Development Facilitation Team (DFT) – Review Comments

Project No: PR-2024-010464 Date: 6/26/2024 Agenda Item: # 7 Zone Atlas Page: F-23

Location: 4901 Glenwood Hills Dr NE between Nube Blanca and Manitoba Dr NE

Application For: VA-2024-00165 – SIDEWALK WAIVER

SITE PLAN
1"=10'-0"

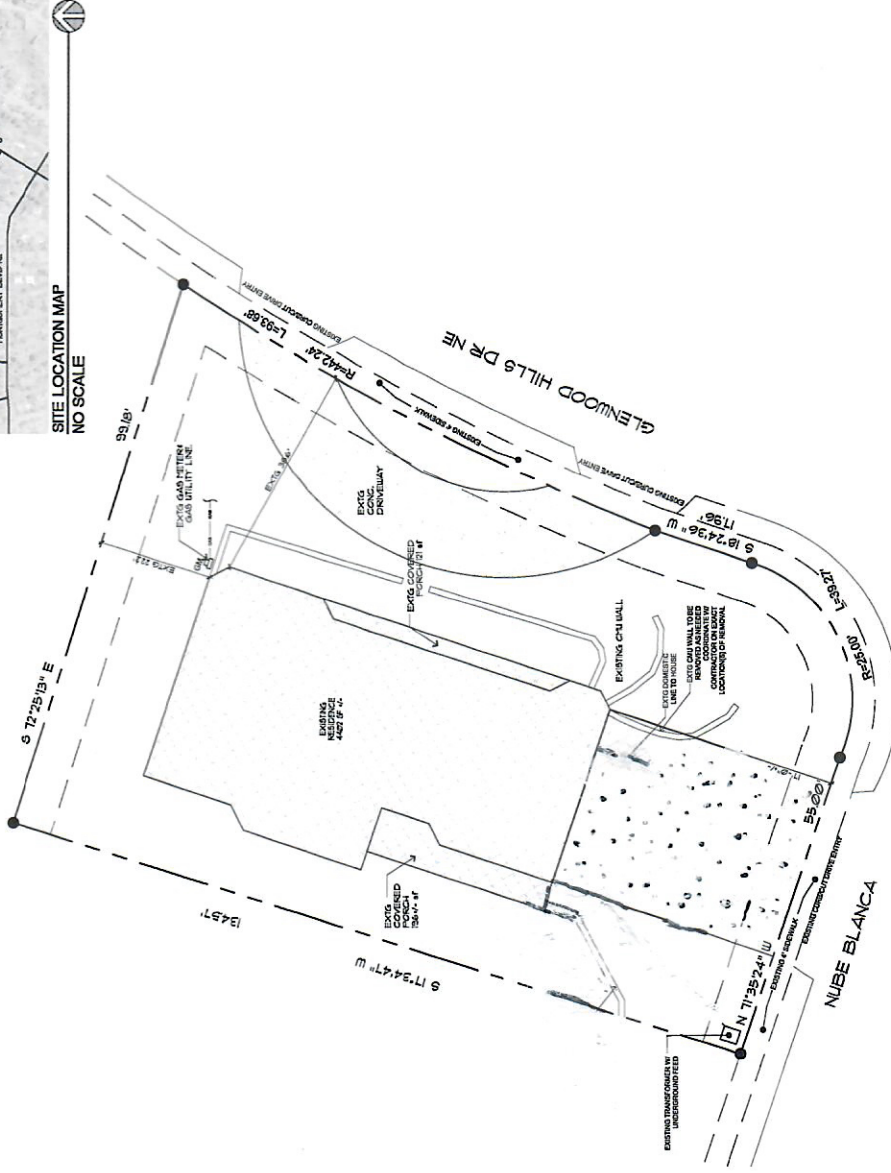
1. Unfortunately, the justification letter does not fully address Transportations comments. Even with a parking pad built to the side this does not eliminate the possibility that someone could park in front of the garage and overhang the sidewalk.

- Planning staff consulted with the City Engineer who noted that the applicant has availability to realign their garage from Glenwood Hills Dr to the east and therefore could avoid the need for a waiver requirement. As per the City Engineer; there has been several complaints from the City Inspector General's office about people parking on the sidewalks. This has been a recurring issue and several violations have been issued in regards this violation.
- Planning staff recommend the applicant withdraws application from the current agenda.
- Provide us with an exhibit where you can show the proposed 10' wide X 22' long concrete pad on the west side of the existing driveway. The diagram should show how vehicles access and fit 'parked' on this new concrete pad.

- Pages #7 and #51 of your current submitted packet the dimension for the “existing concrete driveway to be removed and replaced” shows 17 feet. This waiver request is for 32 inches of the 20’ required not 36”. Dimension should then reflect 17’ 4”; please confirm. Both sheets need to be revised with the correct dimension.
- Confirm that no vehicles will be obstructing the sidewalk at any point. Recent decisions by the City Inspector General mandated that driveways must be 20 feet and allow for the vehicle to be parked without overlapping the sidewalk.
